19th July 2019

I wish to object to planning application 2019/6291836/E housing development planned off Barnsley Road, Denby Dale and have consulted the expert advice of _____ and

ENGINEERING FEASIBILITY

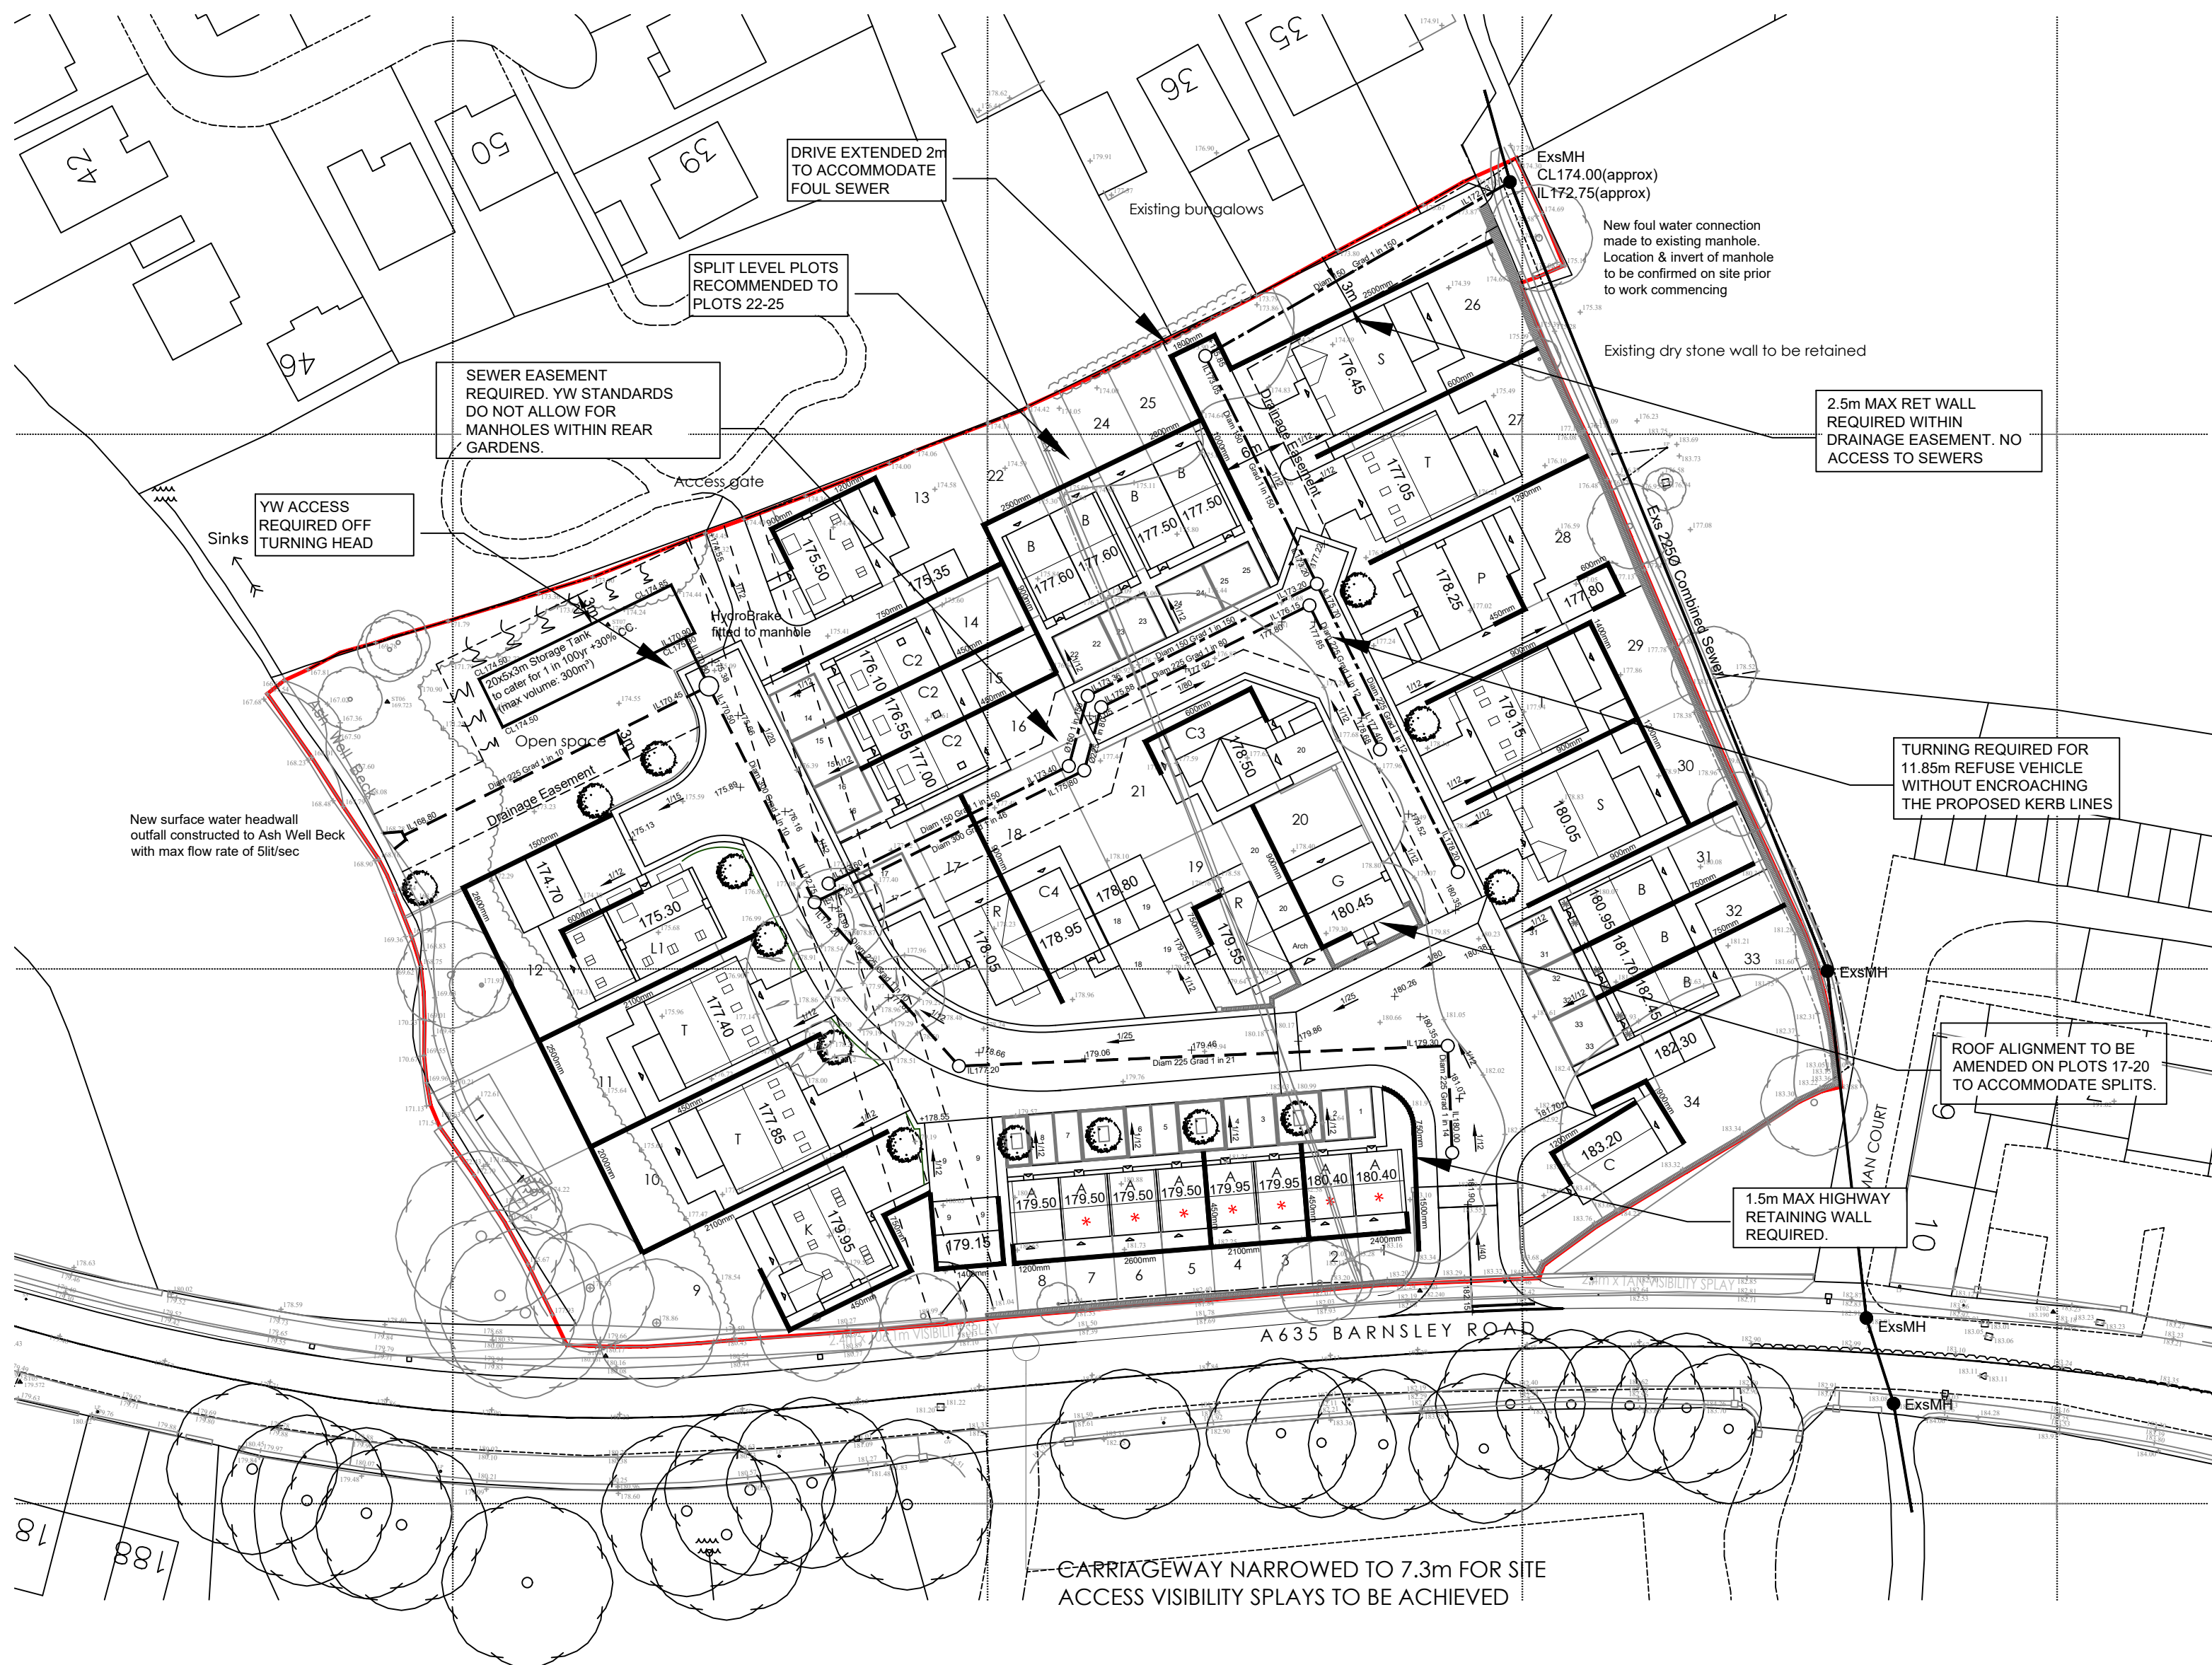
Diligent consideration has not been given to the drainage from this proposed development. I am already aware from a local resident that the property developer's (Yorkshire Country Properties), engineer was shocked that his plans are incorrect and that the main sewerage pipe is not in the right place on submitted plans. It should not be for local residents to have to find these errors and that in fact these pipes actually go under a house which has previously had to have damaged sewage pipes mended and is affected daily by noise. Denby Dale has an ageing sewage and drainage system which will be further stressed by yet another development.

The proposed site for these 34 dwellings absorbs surface water as a natural soak away. This will be replaced by water tanks built underground to take the surface water that would have been absorbed naturally by the fields and positioned close to an existing beck that the plans indicate will be drip fed by the water tanks. The flood report that has being undertaken states that the water tank alone is not sufficient to cope with a 1 in 30 year event. The plans show no indication of the suggested reed beds or ponds required to support the drainage. I would suggest that in place of this site has been maximised for housing to support gaining approval against the local plan. The developer has again not shown diligence or duty of care to the existing community. Residents of Kenyon Bank, Dearnside Rd, have suffered damage and great inconvenience and personal cost during floods of 2007. Kenyon Bank residents regularly check the beck for blockages so as to avert problems. These issues should be well known by Kirklees and I would suggest need urgent review.

Page 28 design and access statement "Surface water is likely to flow from north to south across the site and flood routing has informed the structure of the concept design. On site attenuation, to store critical in 30 year storm, is required. Due to topography, storage will be located in the north-west corner of the site, underground." This is wholly inaccurate this land is elevated and slopes south to north.
